Re: Planning Application 24/00703/F
22 Turnstone Green Bicester OX26 6TT

I wish to strongly object to the first floor side extension of the planning application No: 24/00703/F at 22 Turnstone Green, Bicester OX26 6TT. I am an immediate neighbour of the above mentioned address.

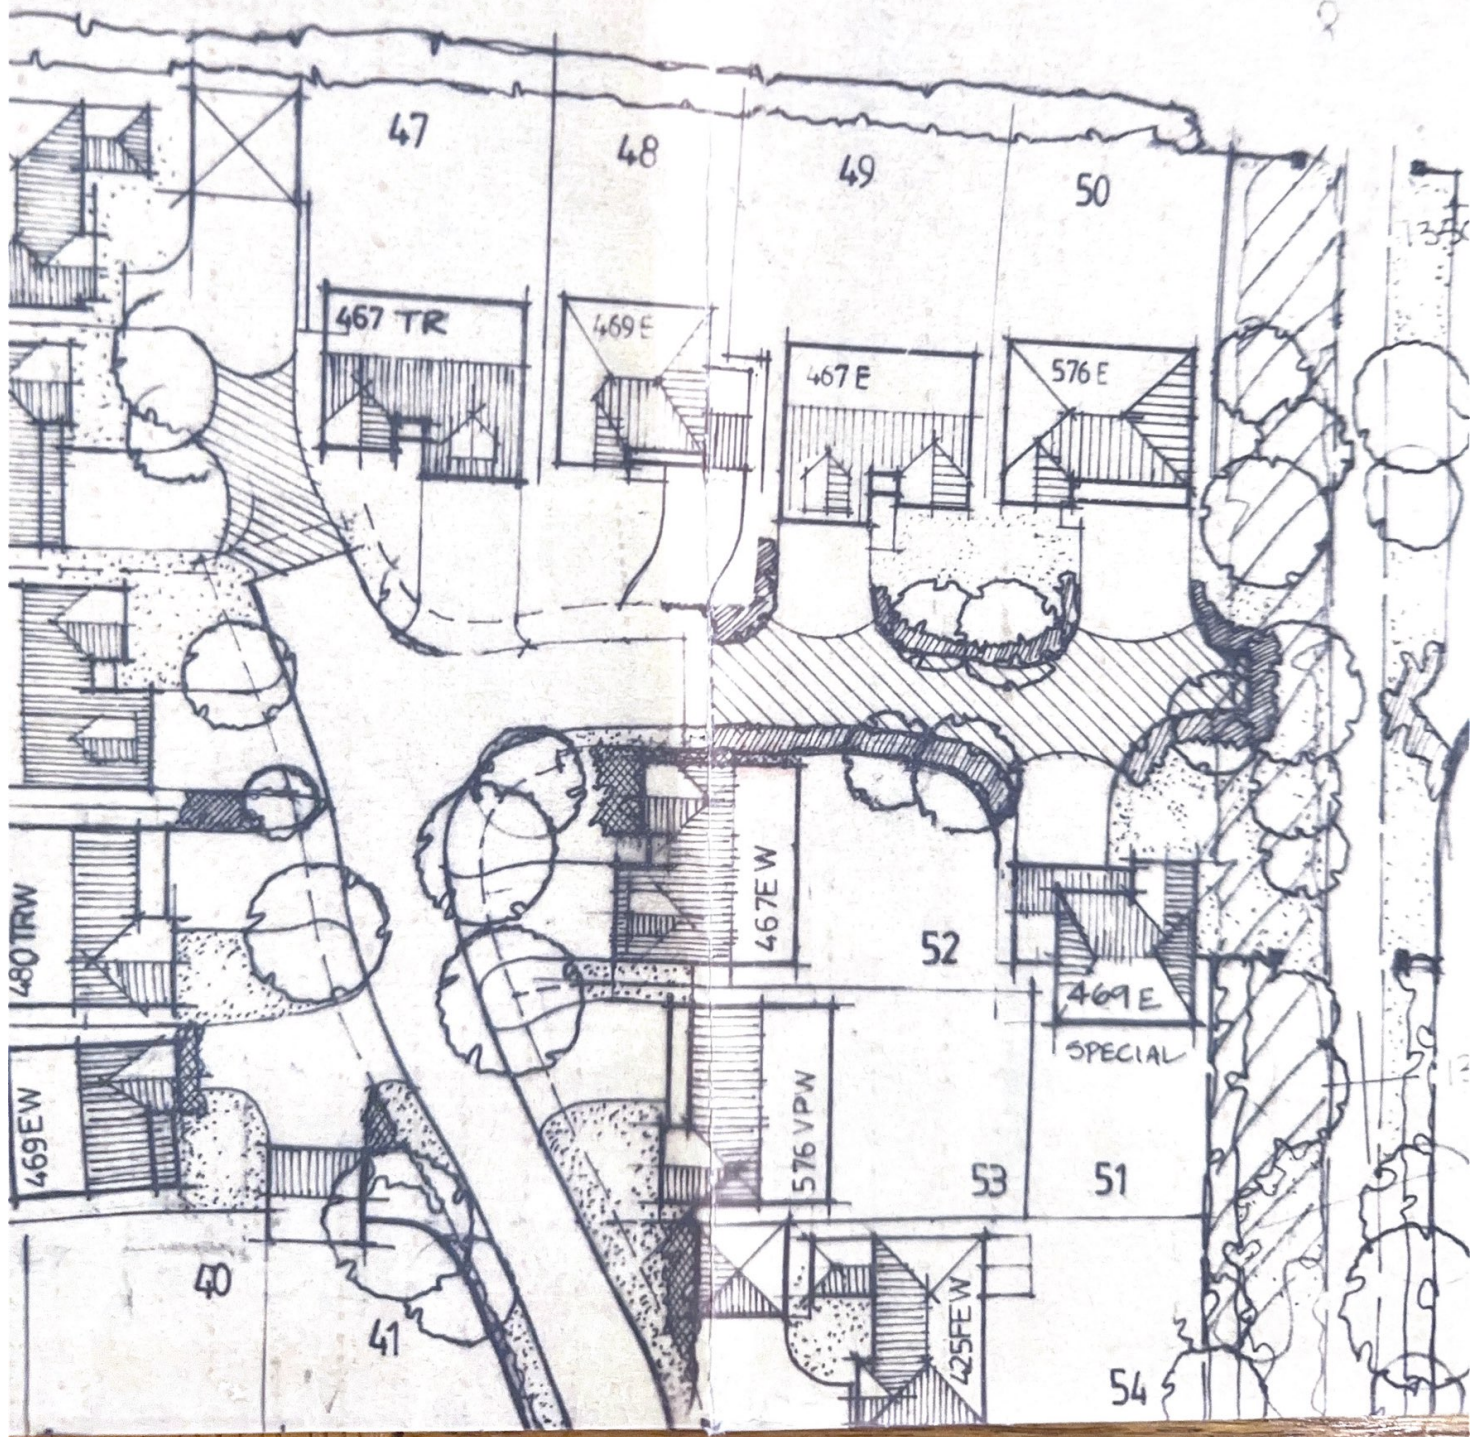
At the time of our purchase, No 22 (plot 48) was to have a double stand alone brick garage at the front and this indicated the boundary of our property at the front and we had more land to the side of our dwelling. The road in the front of our property (No 20) is not public highway, but private land. The title deeds to our property (No 20) stipulate access allowance across the said road to No 18 and 16 with maintenance of any part of the road divided between the 3 dwellings. I submit with this letter

site plans (Attachment 2) indicating the original proposed position of the garage of No 22, the boundaries and the landscape planting against the walls. Fences were erected between the properties prior to us moving in as per these plans.

The repositioning of the garage and fence (reducing the land at the side of our property) between the two properties is shown in Attachment 3, Plot 48 is No 22 and Plot 49 is No 20. We did not expect further development on the side of No 22.

The block plan submitted with the Planning Application is incorrect. Please refer to Attachment 2 to show the correct outline of No 22 (Plot 48) in relationship to No 20 (Plot 49). No 20 has access to my back door and the rear garden by a side entrance through a gated access with fencing. The “boundary line” does not cut across to the wall of my house as shown in the submitted block plan of this application. There is a pathway to my drive. As detailed before boundaries are relevant, because of certain conditions and clauses of my title deeds. The site size of No 22 is not equivalent to other sites of 5 bedroom dwellings in Turnstone Green, suggesting overcrowding of the site.

Proposed Southeast (front) Elevation
1:100

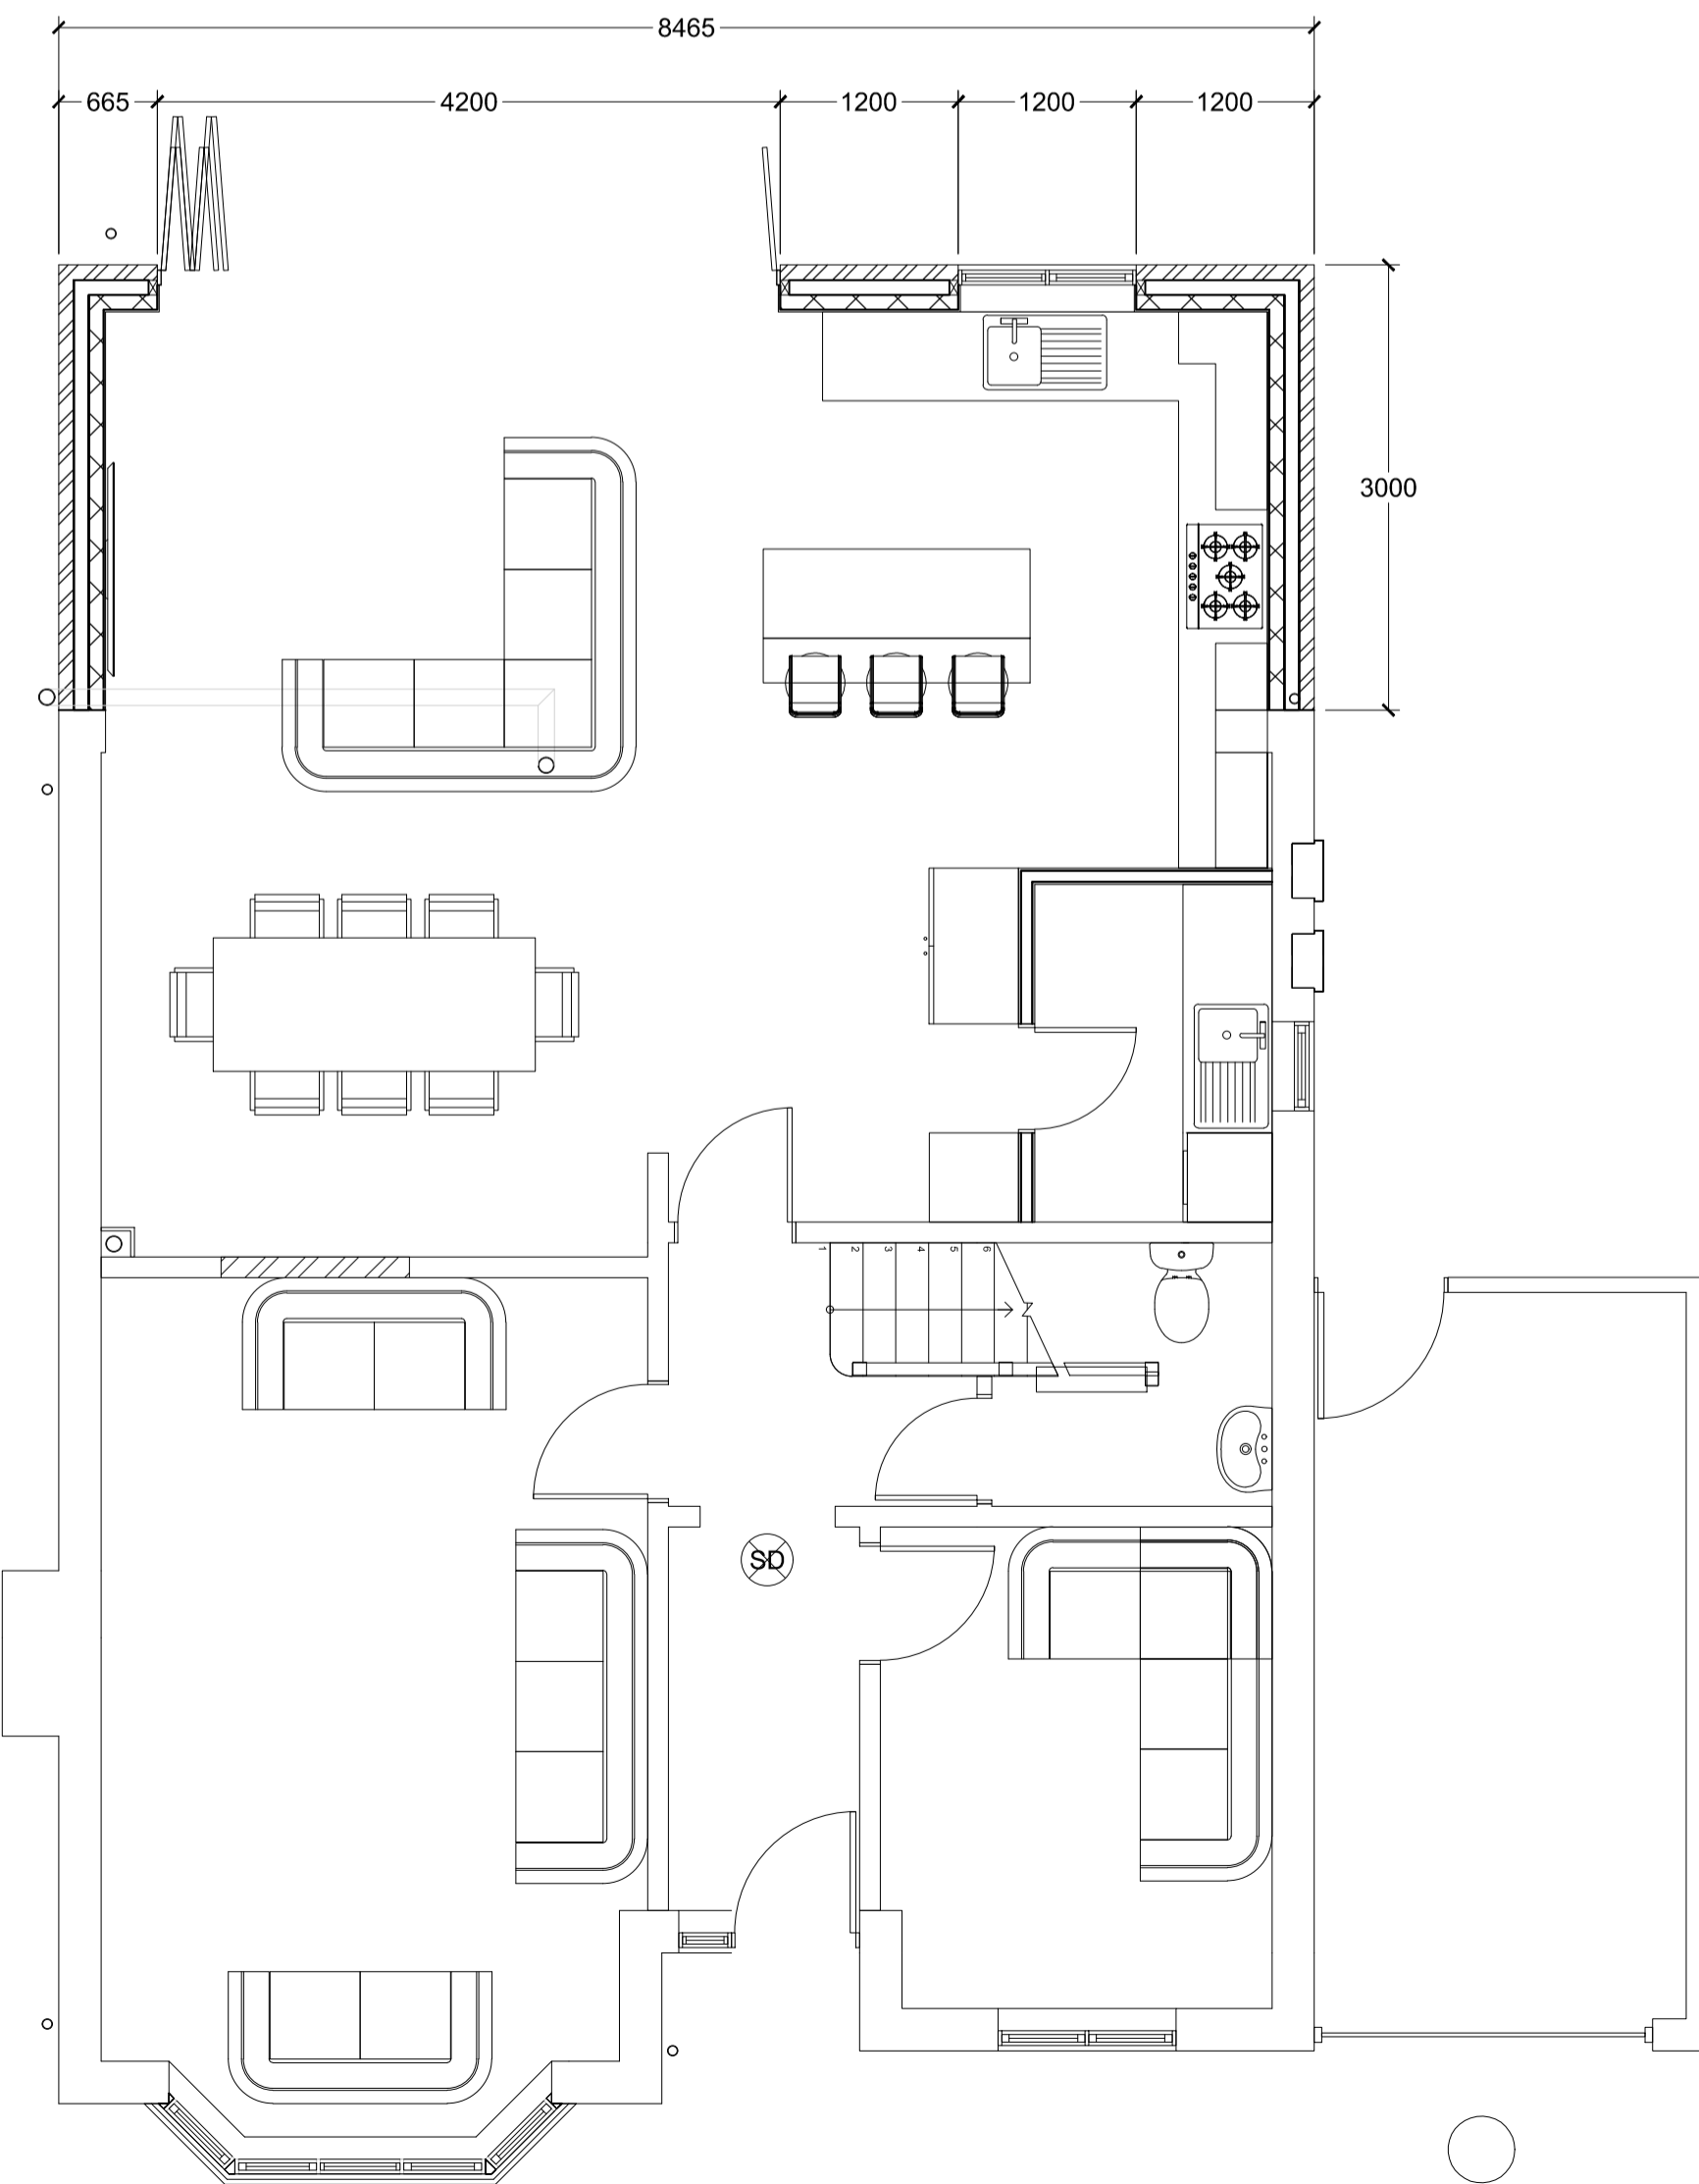
I have concerns whether the building materials particularly for the front elevation of the second storey side extension can be found to match the existing materials in colour, texture and mortar colour, the latter being very specific. No 12 is built in the same buff coloured and textured bricks and the rear extension built recently (seen from my bedroom window) is of a much brighter yellow and different texture. If materials like this are used for the front elevation it would not meet with the character of the surrounding dwellings.

An attractive amenity of owning No 20 was the size of the garden and the space between No 20 and 22 allowing sunlight through the gap to the back garden. The erection of the current garage on the side of No 22 reduced this, which we accepted for a better outlook at the front of our property. The present garage on the side of No 22 has an exit only to the back positioned at the time of build, for our privacy. I observe that the proposed ground floor plan of the garage, sites a door on the side, as well as to the back. The wall of the present garage is 750 mm (0.75m) from my fence giving a very narrow pathway down the side of No 22 to the rear garden. I propose this exit is too close to my fence intruding on my privacy.
